Dear Mr Crowther **Planning Application M/80/19/PL**

I write to make further comments on Frontier Estates' proposals for the redevelopment of the Yapton Road Poultry Farm here in Middleton.

SITE LAYOUT

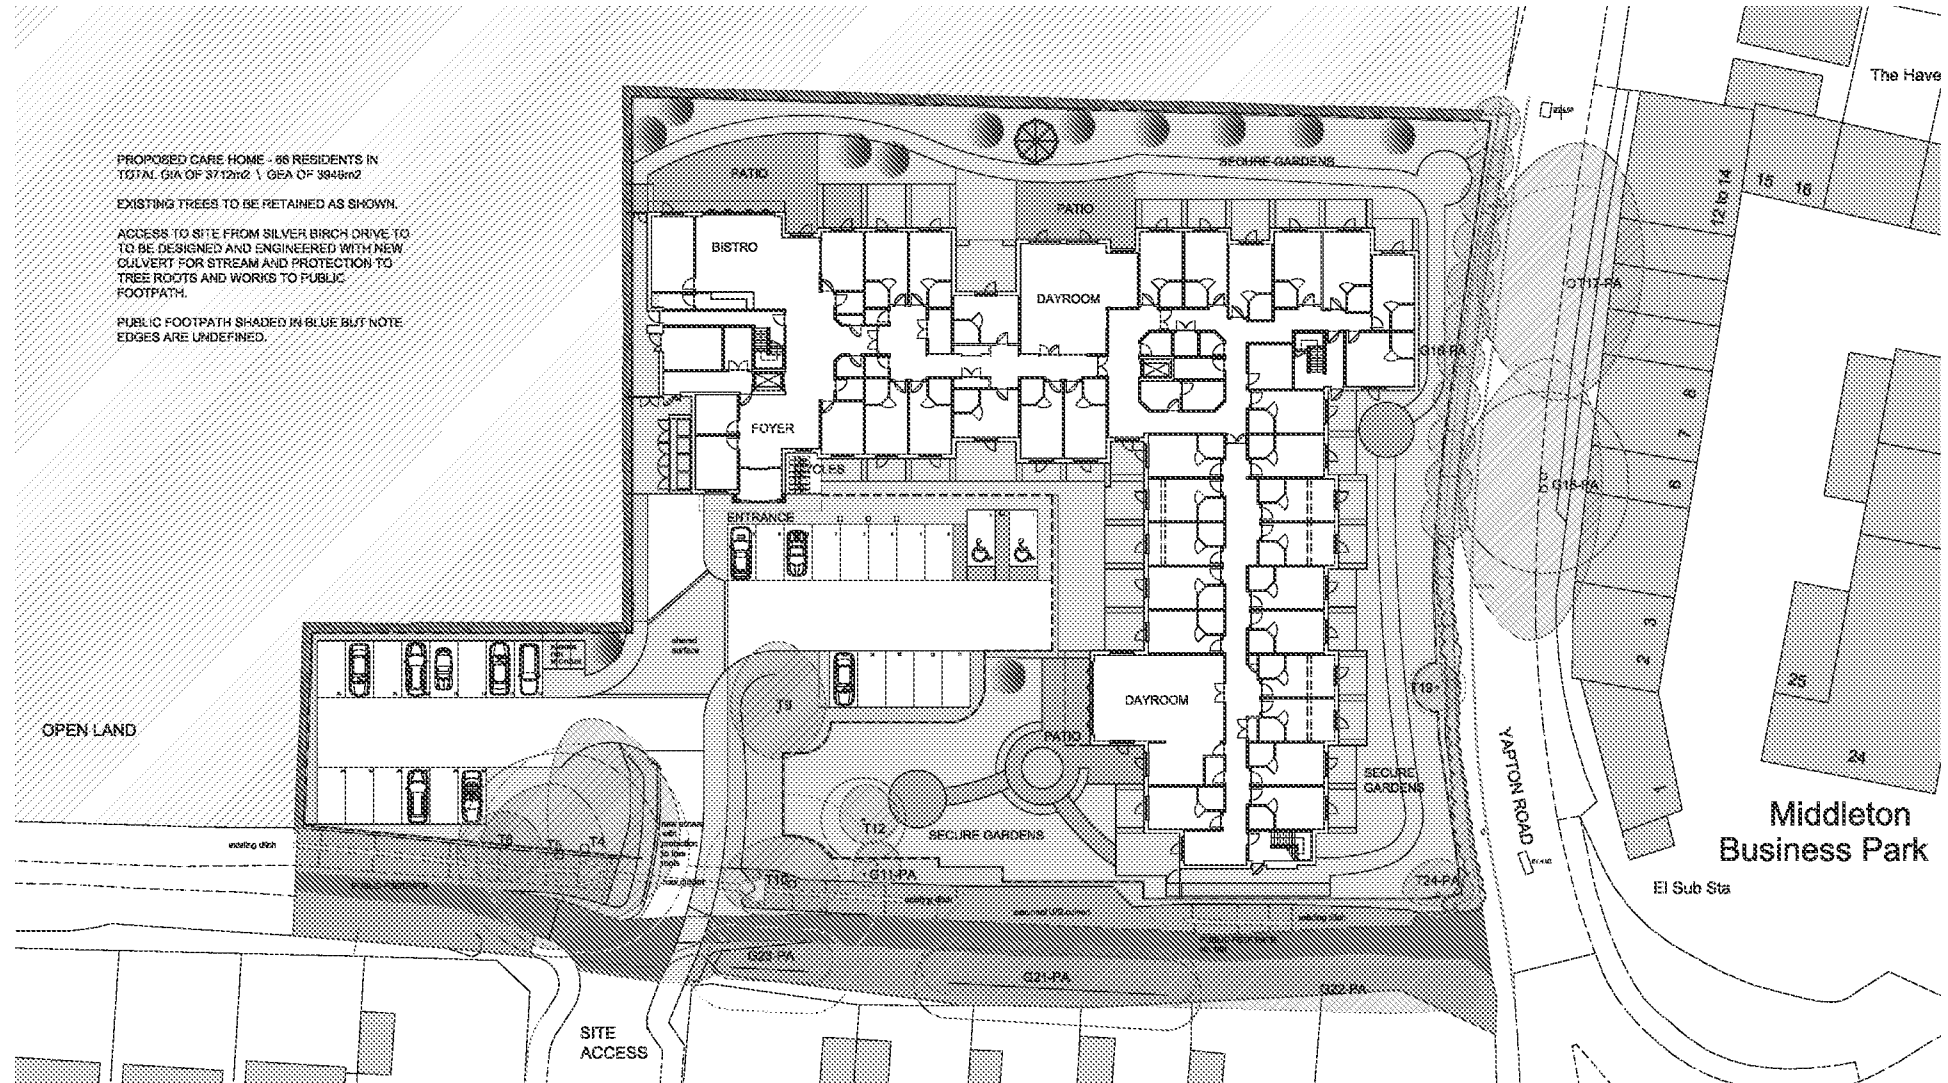
The concerns I flagged up in my previous letter still apply. Not enough parking within the care home site for staff, visitors, professionals like doctors, maintenance and cleaning staff.

Difficulty for drivers entering and leaving the home along a single-width stretch from the pathway on the southern edge of the site into the paved area in front of the home's main entrance. Such vehicles as ambulances, dust carts, food and medicine delivery vehicles, will get in each others' way.
